EPC STORMWATER REVIEW COMMENTS  
IN ORANGE BOXES WITH BLACK TEXT

# CIVIL DRAWINGS FOR MERIDIAN RANCH FIELD HOUSE

## IMPROVEMENT PLANS

**El Paso County**  
Major Commercial Site  
Development Plan

C2.0

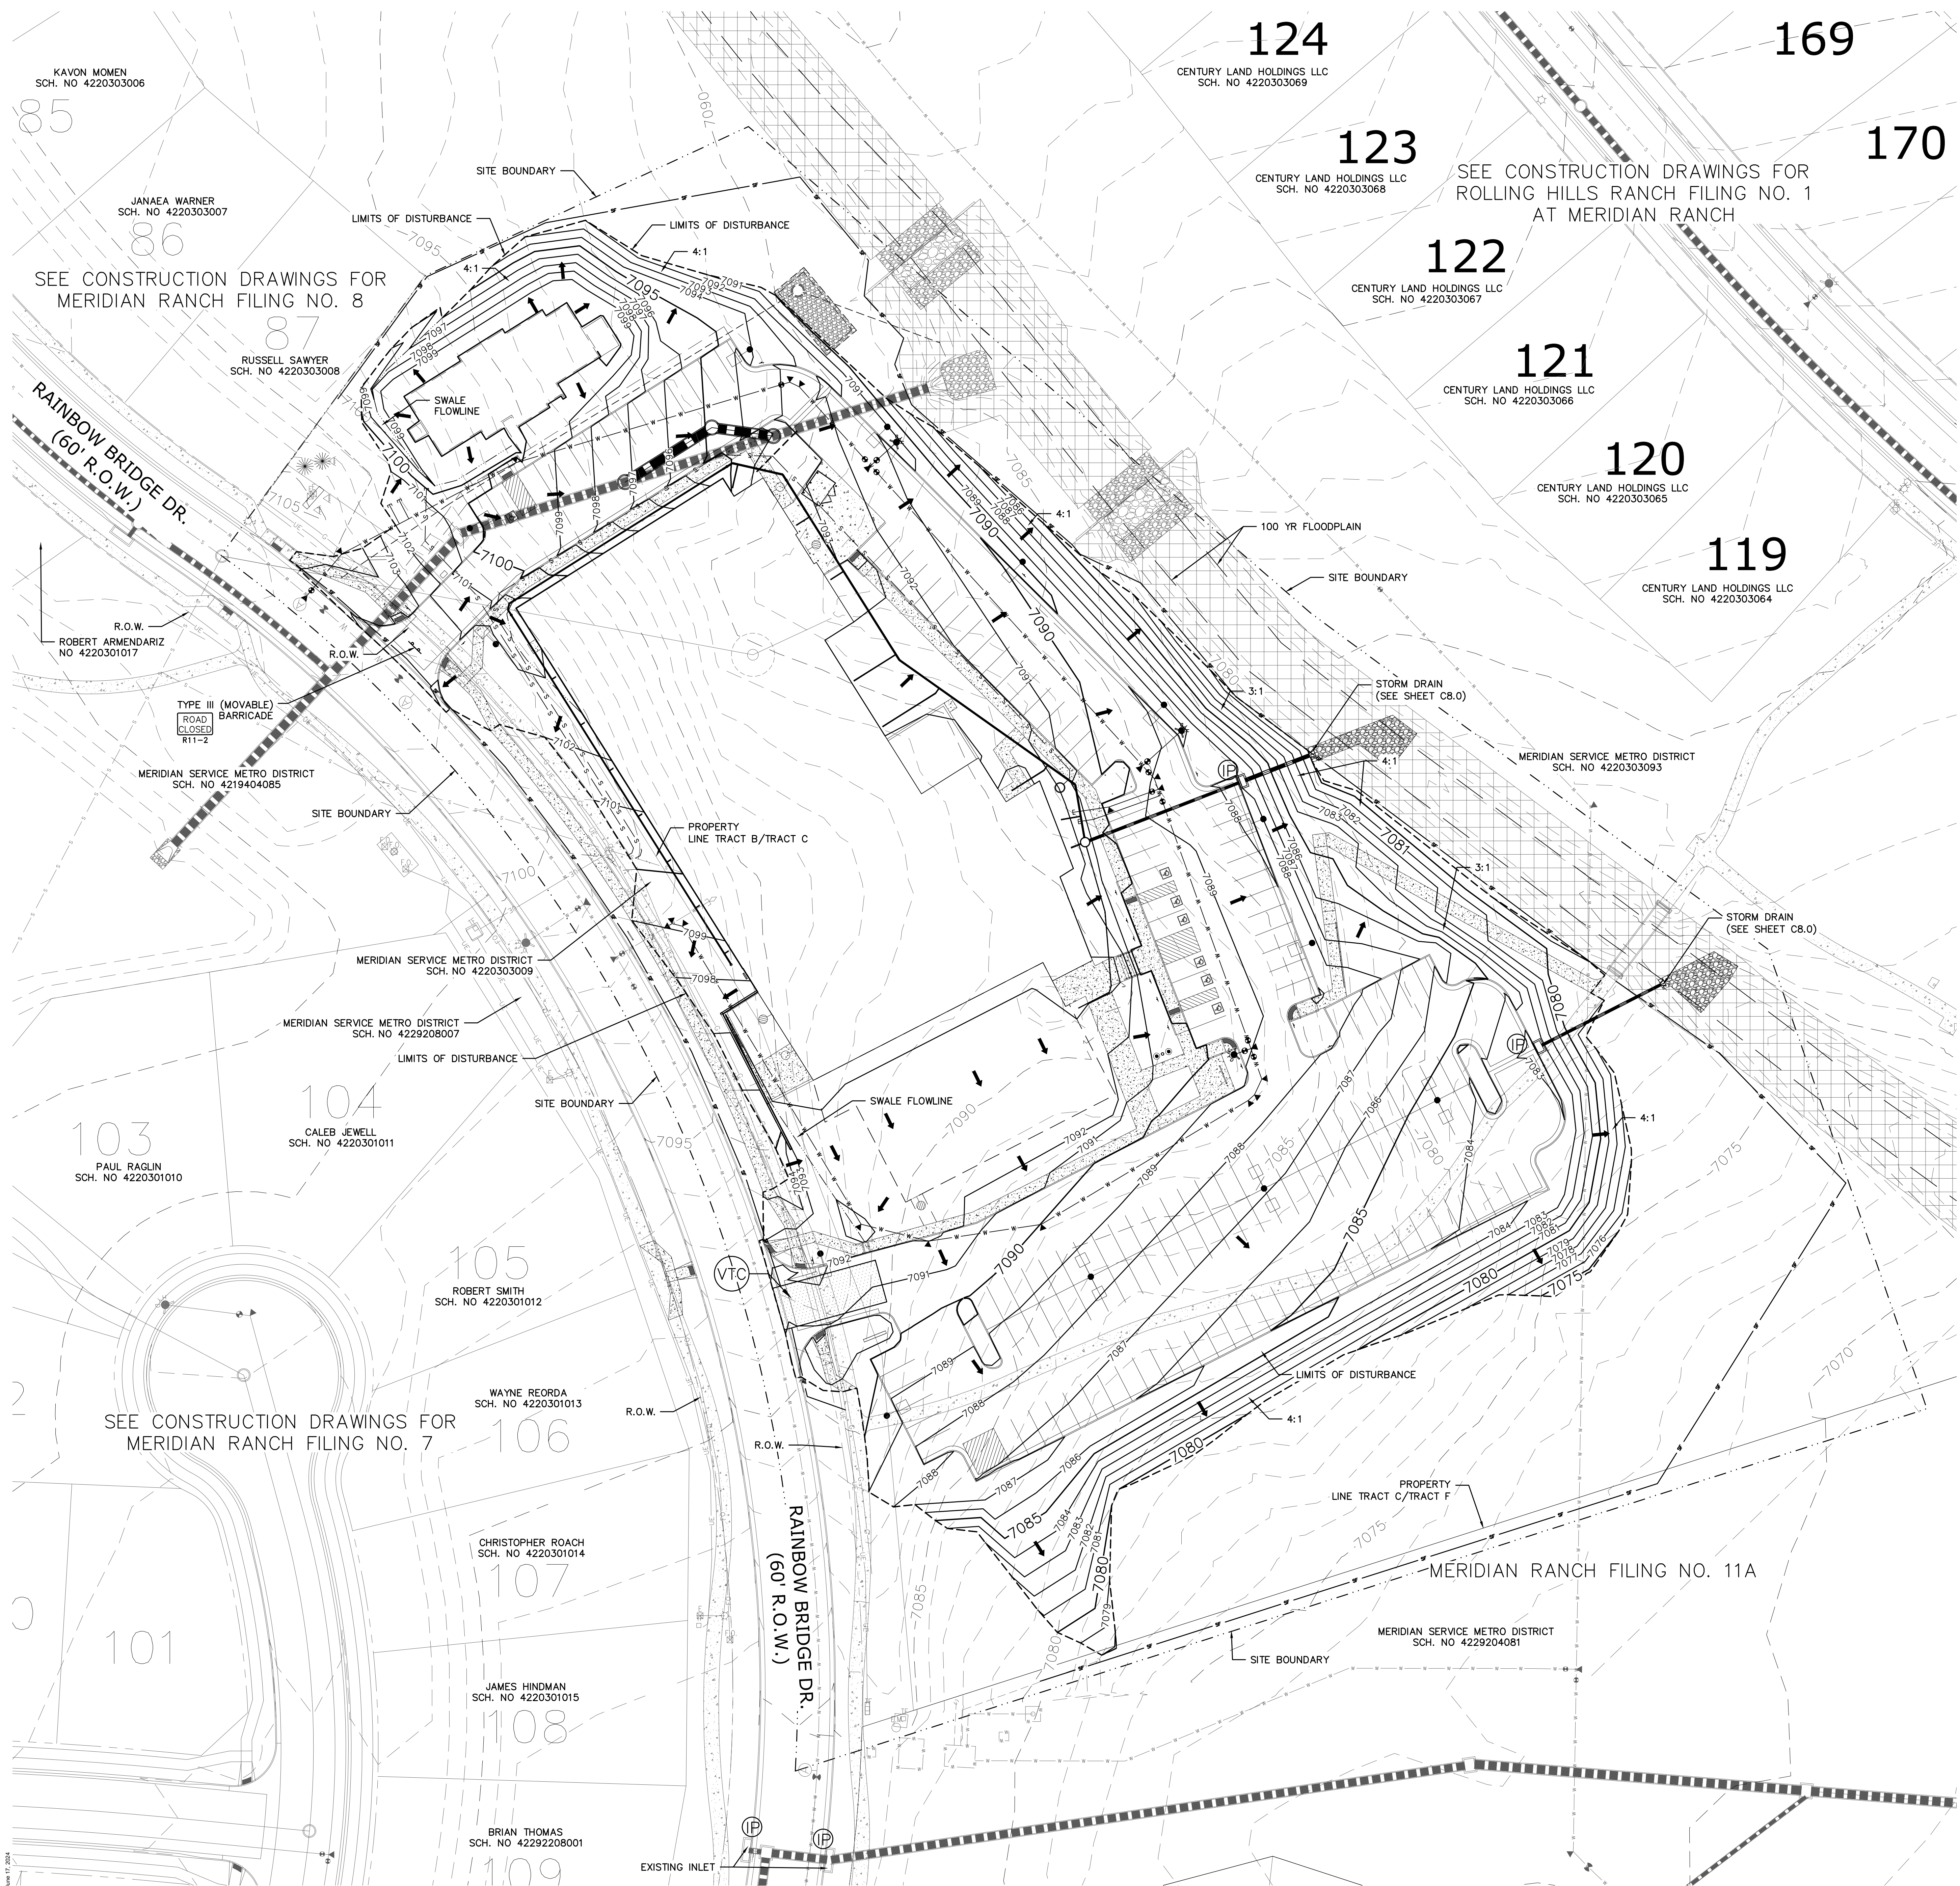
Please see comments on the drainage report and provide calculations for this swale. We would want to see velocities so we can confirm if erosion will be an issue between the proposed grading and the channel.

Swale ends here where it essentially become sheet flow. The 100 yr flood velocity of this basin is 1.2 CFS. This area is about 1/3 of that basin. The volumes and velocities are not significant enough to warrant analyses. Where the swale ends there is a 4:1 slope at 2% slope. Even assuming half (0.6 CFS) to this point would only have a velocity of 1.87 ft/s. So not even close to erosive velocities.

C4.1

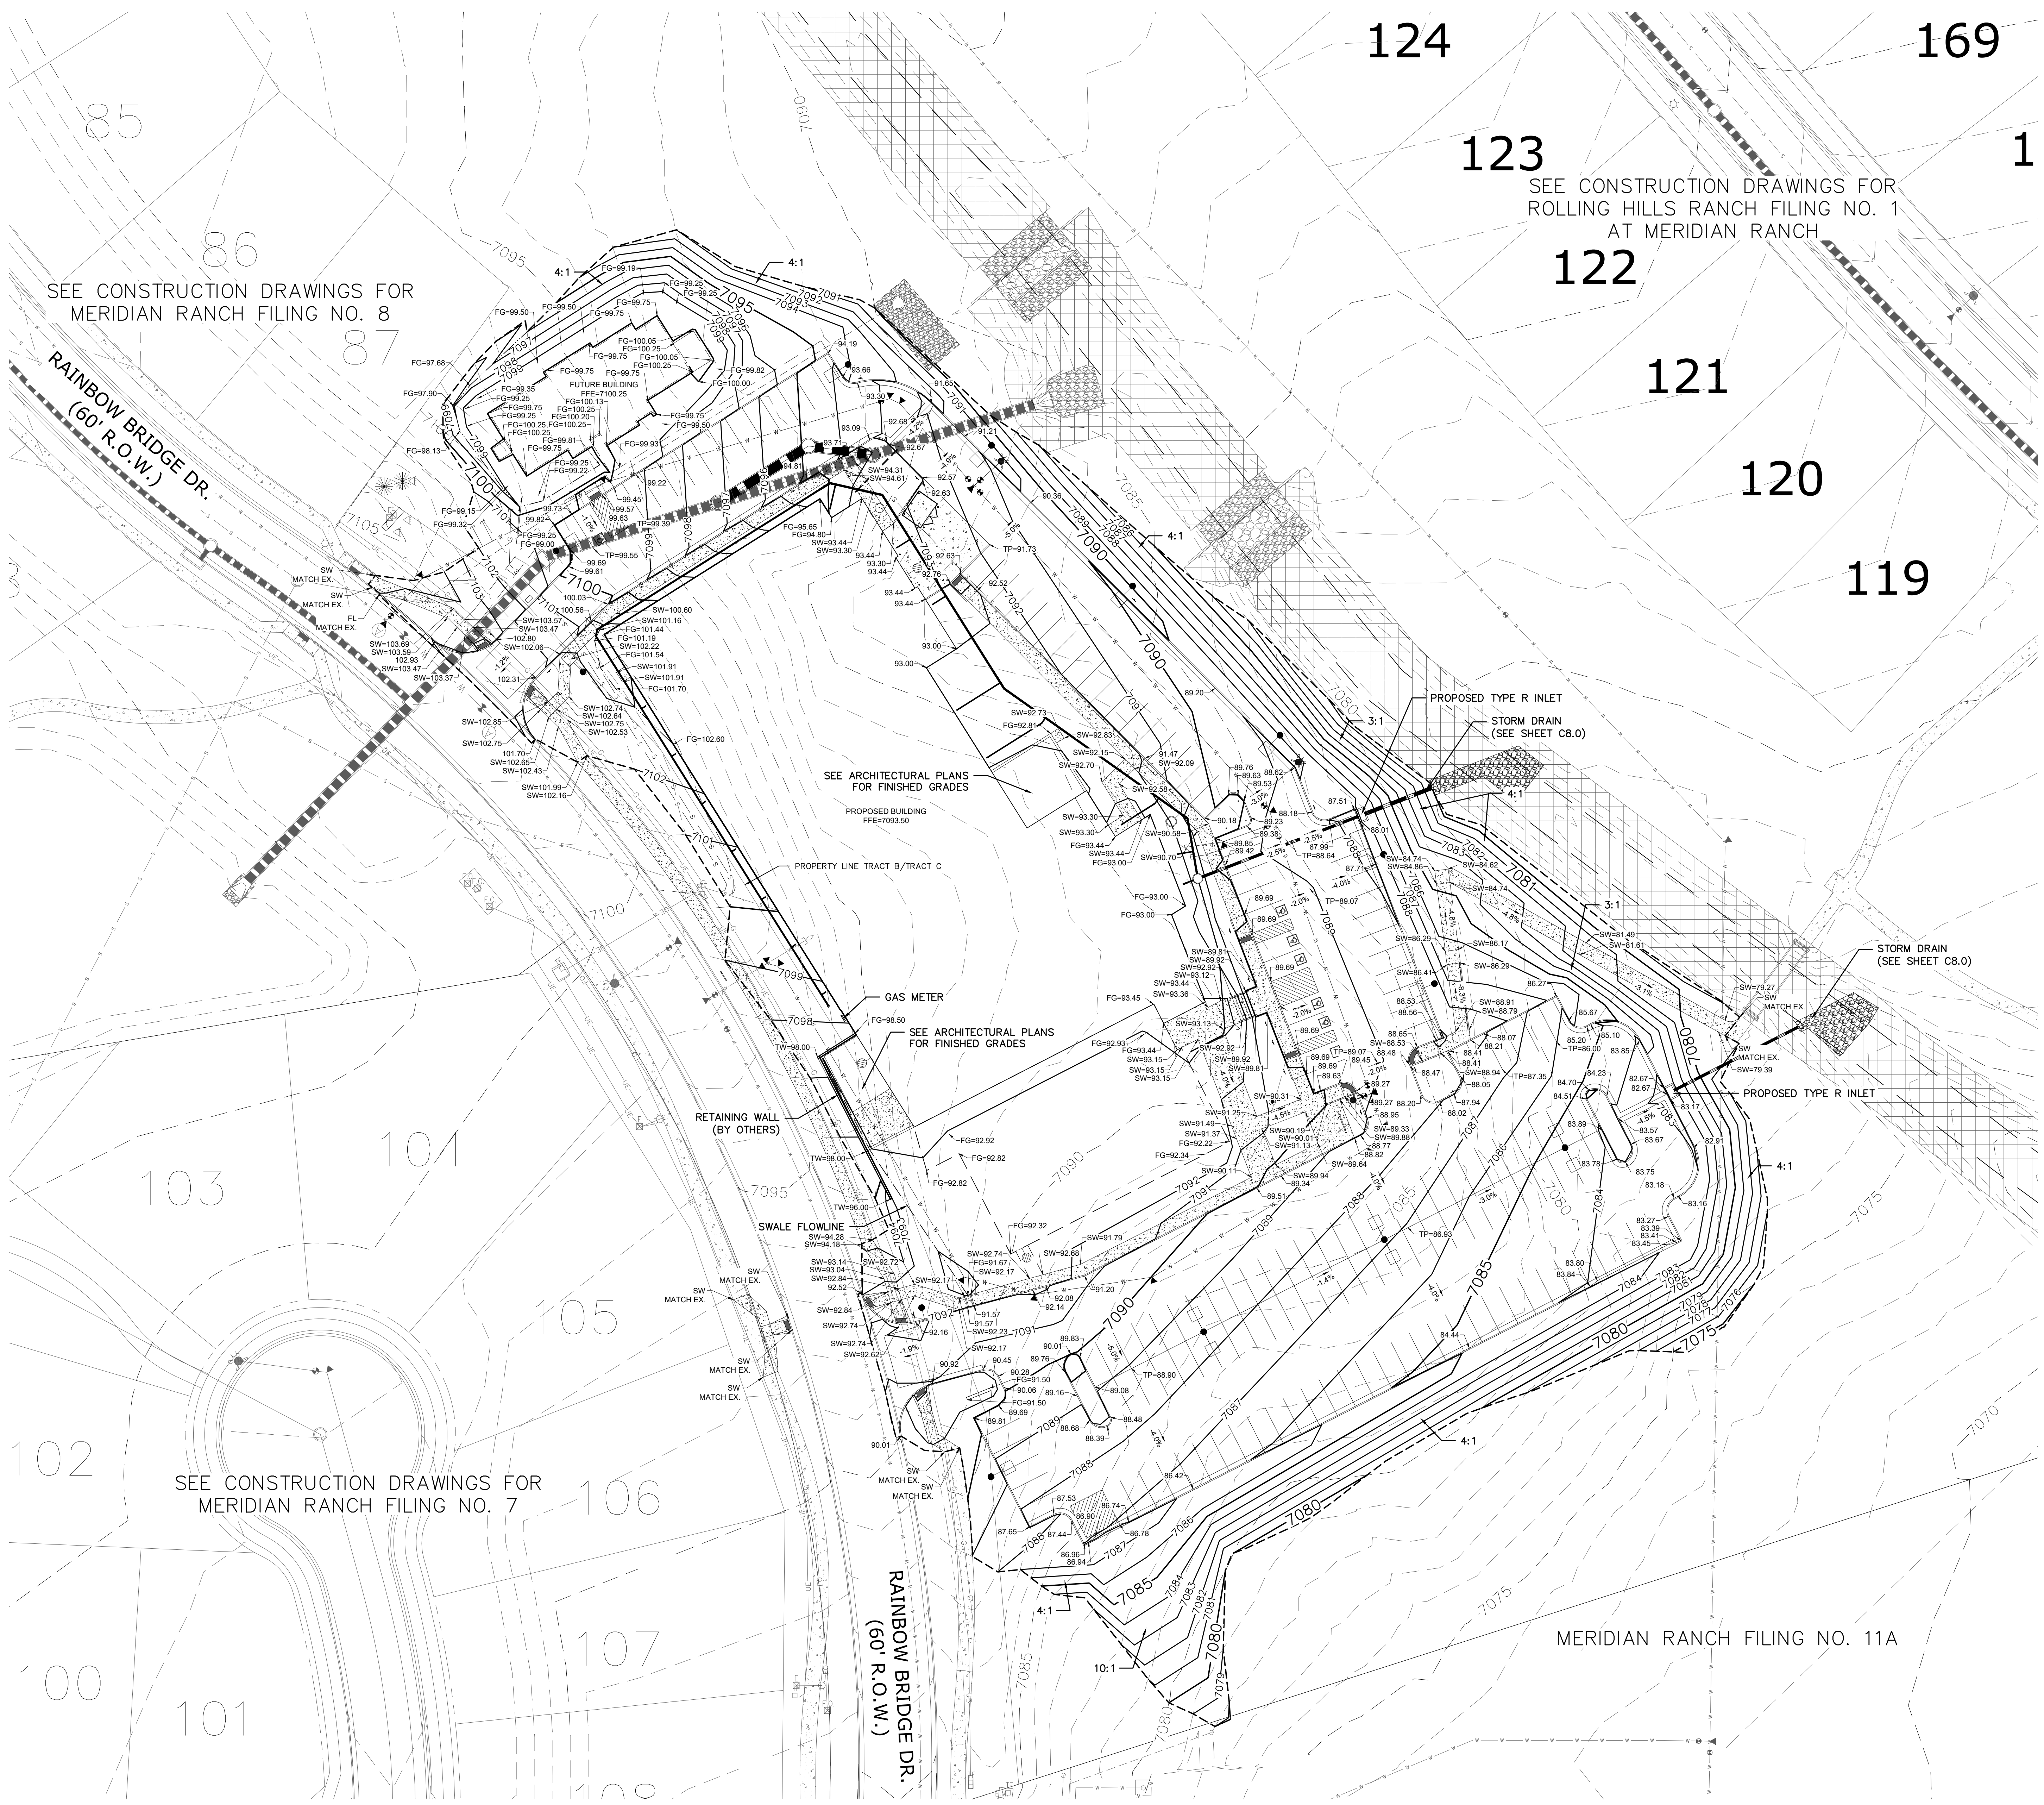
Identify the curb return radius at the access points  
 Point 228 is the center of radius.  
 See clouded on the tables sheet C4.1
